136 Commercial Street BP 2016-02082

1 PROPOSED FIFTH FLOOR PLAN
AE105 SCALE: 1/4"=1'-0"

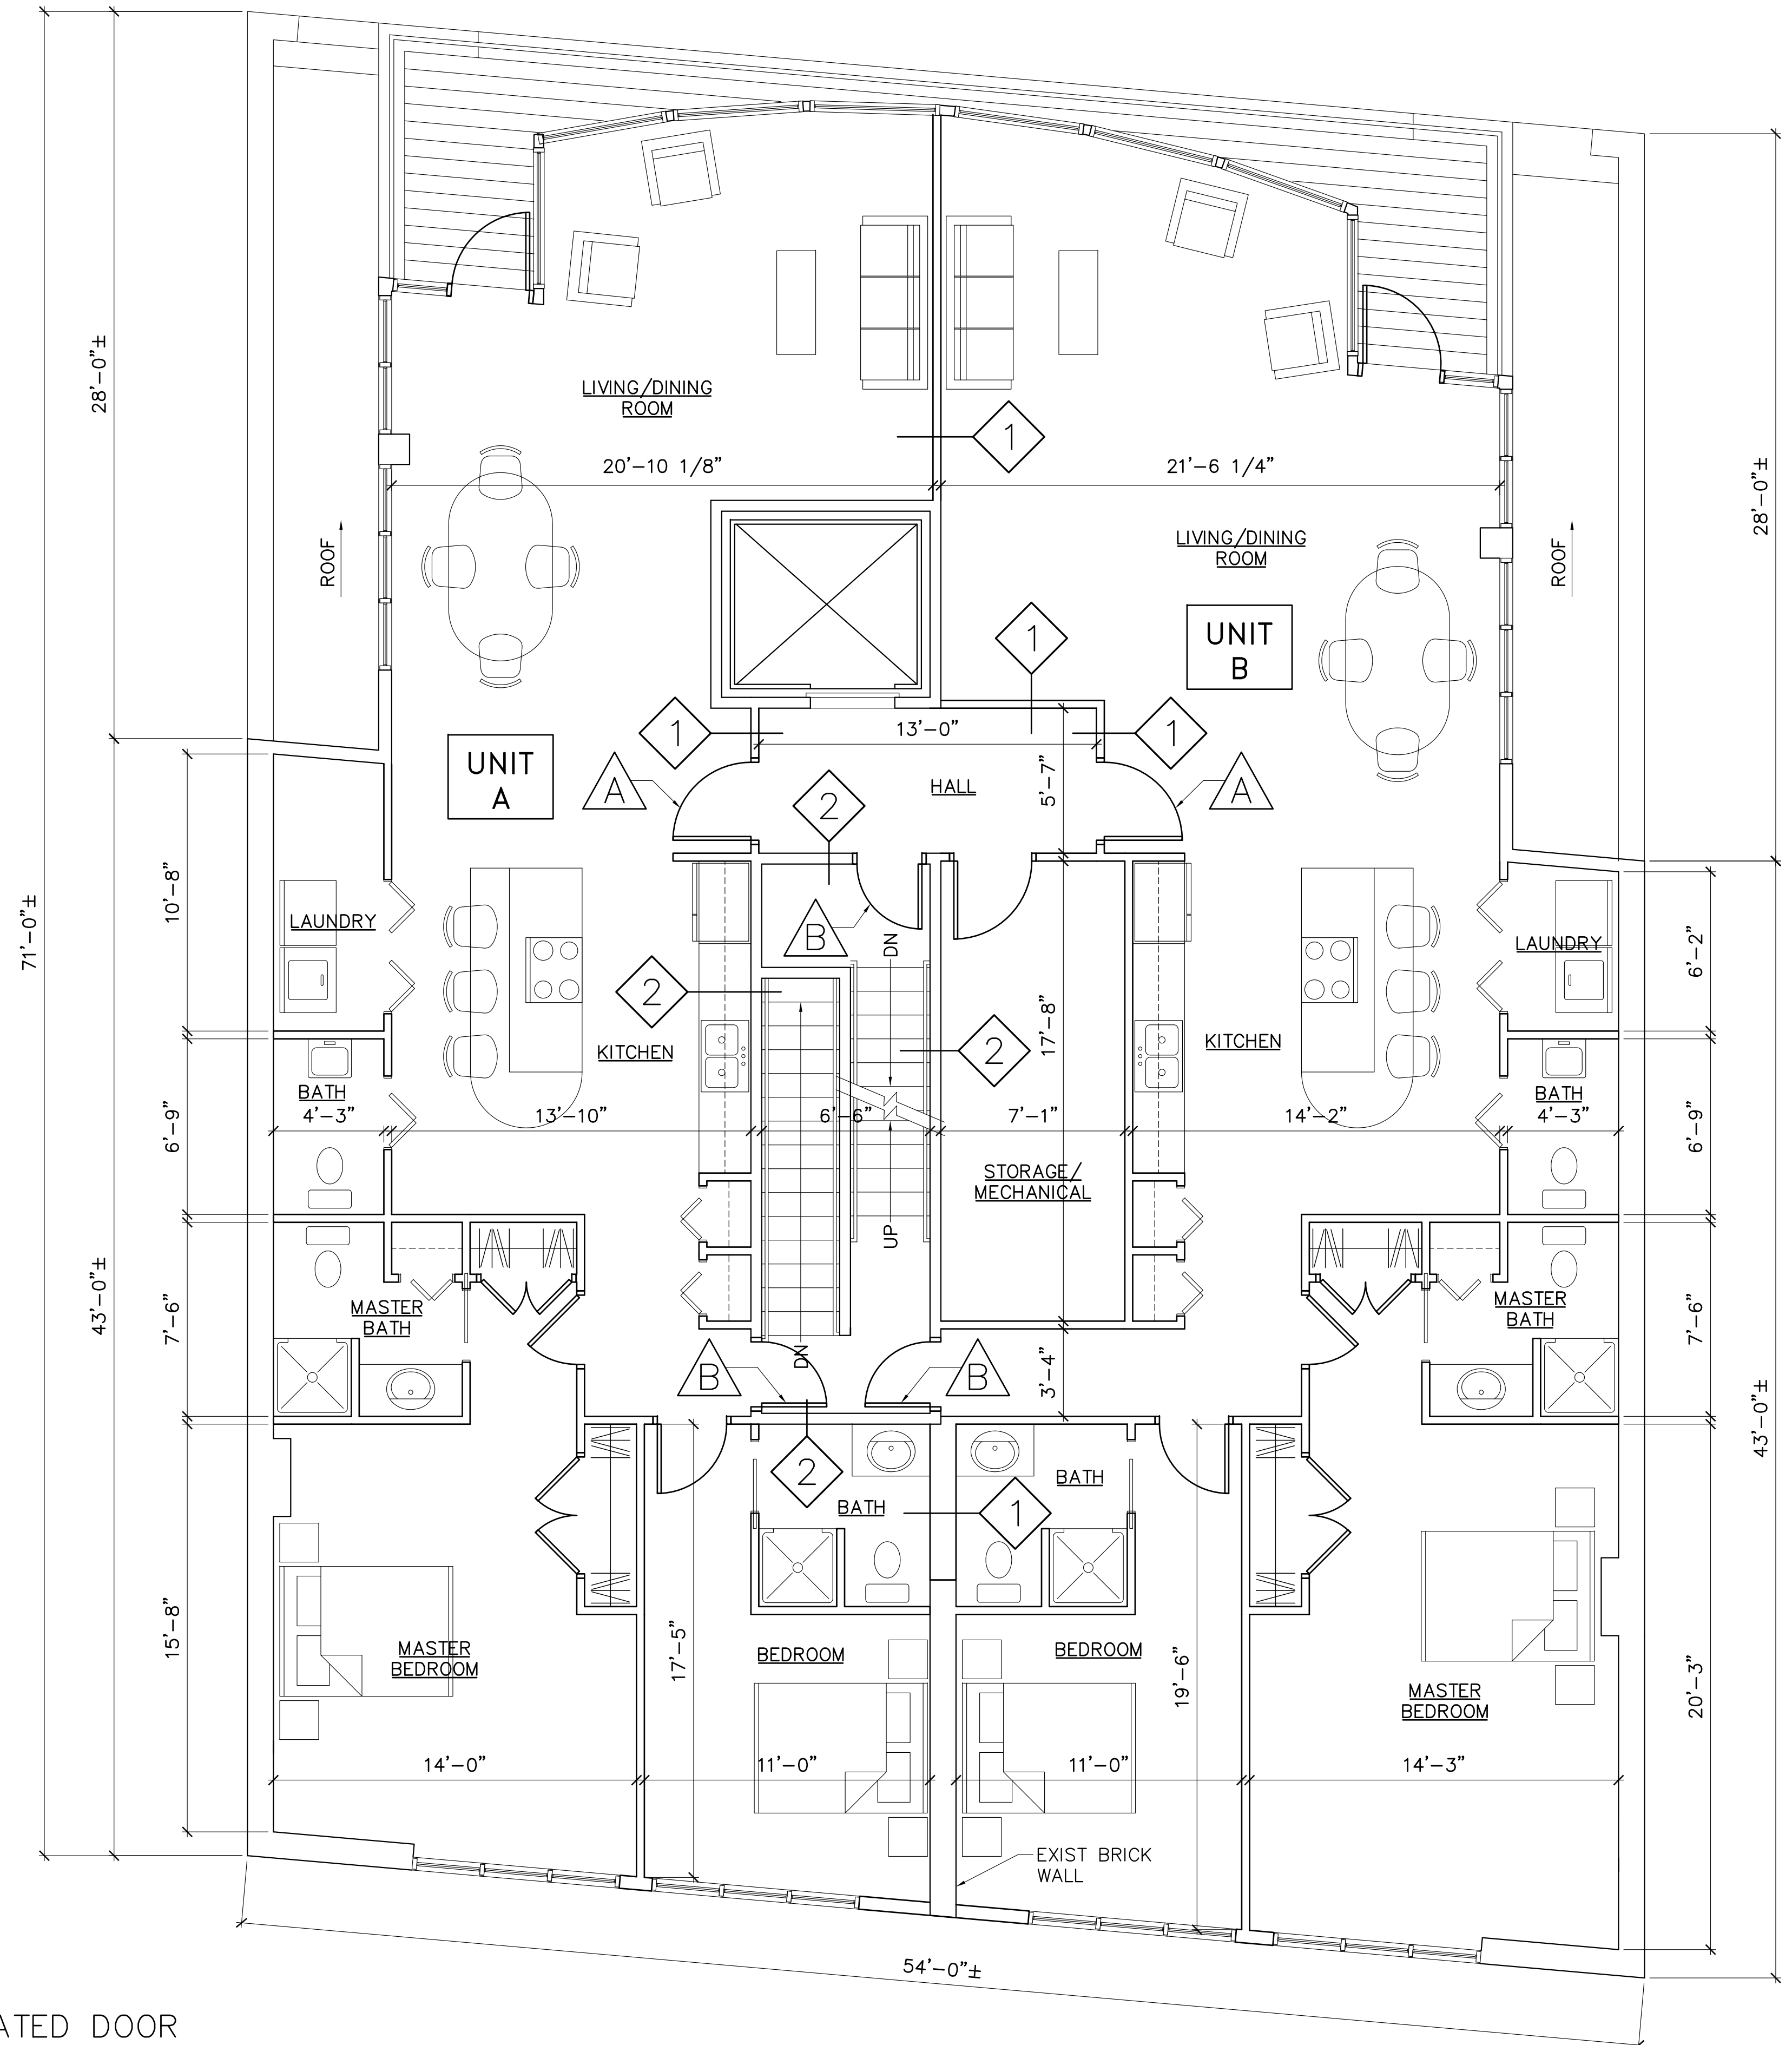
Thank you for your responses. In regards to the R-1/R-3 uses, I understand that they will need to get a change of use permit in the future for the R-1 occupancy, however, your code review reference (310.1) states all standards apply for the R-3 use, when it is only for the construction type.

It does not take into consideration egress requirements, and as Sec. 1015.2.1 indicates, scissor stairs only count as one exit stairway, which may be acceptable for an R-3 use, but not necessarily for an R-1 use.

If the intent of this review is to pursue approval for an R-1 use, this is cannot be done with the information provided, therefore the reference needs to be clarified, or the full code review needs to be included.

- 1.Existing building is HT, the new fit up is IIIA.
- 2.Guard rail is existing metal pipe rail, 48" +/- above deck.
- 3.The separation between B and R is 1hr with sprinkler given the HT construction.Penetrations will be firestopped.
4. Attached is wall type 1A detail for construction.
5. The smokes/CO2 devices will come from the electrical sub.

I'm uncertain as to how to respond to the R1/R3 issue as this is being constructed as an R3 apartment. The lawyer handling the zoning concern advised me to include that reference. The ultimate use is beyond my scope.

Would you remove the note about the R1 transient lodging use and send back to Jeanie Bourke at the city please for her review thanks
